4 July 2018

RMS Reference: SYD17/00339/03 (A22993125)
DP&E Ref: SSD 8310

RESPONSE TO SUBMISSION (RTS) FOR THE RE-DEVELOPMENT OF CURL CURL NORTH PUBLIC SCHOOL IN PLAYFAIR ROAD, NORTH CURL CURL

View of Children's Crossing on Playfair Road with no kerb ramps

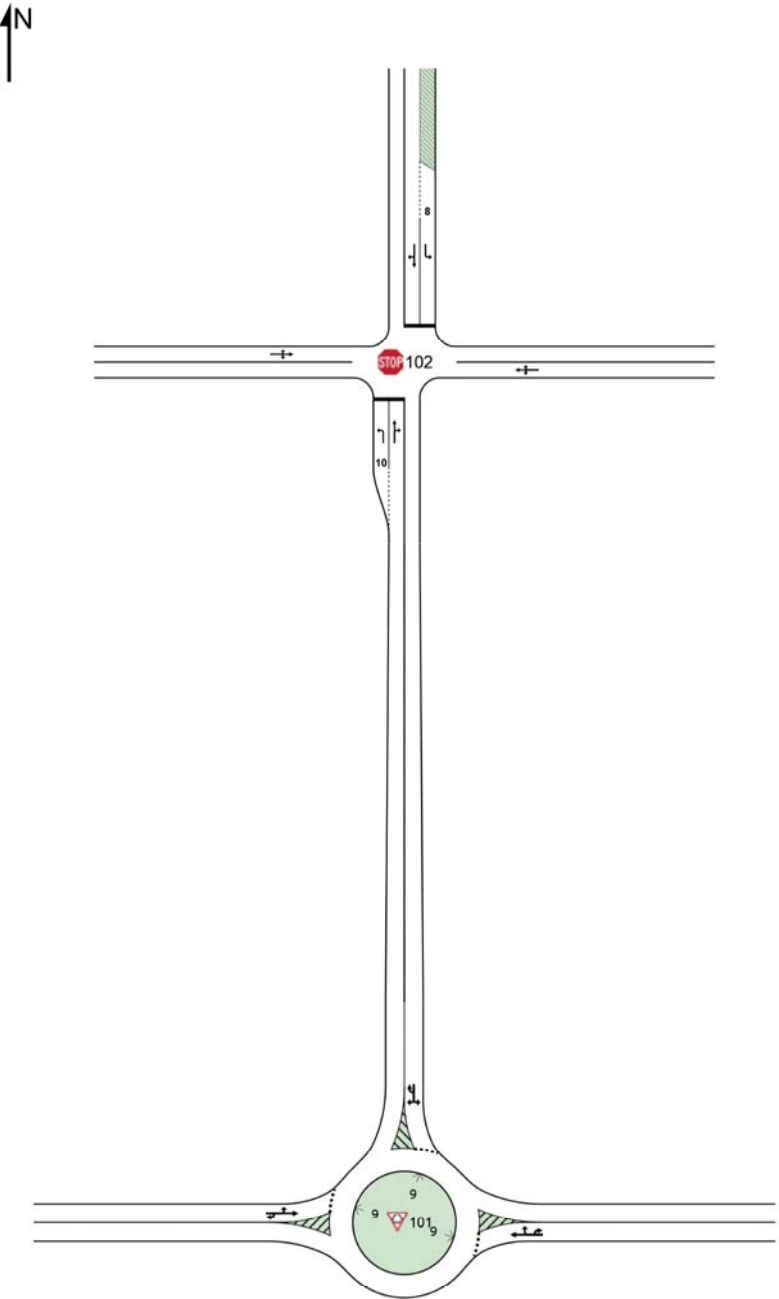
1. Proposed removal of existing Children's Crossing on Playfair Road to provide additional drop-off and pick-up facility is subject to approval by the Local Traffic Committee.
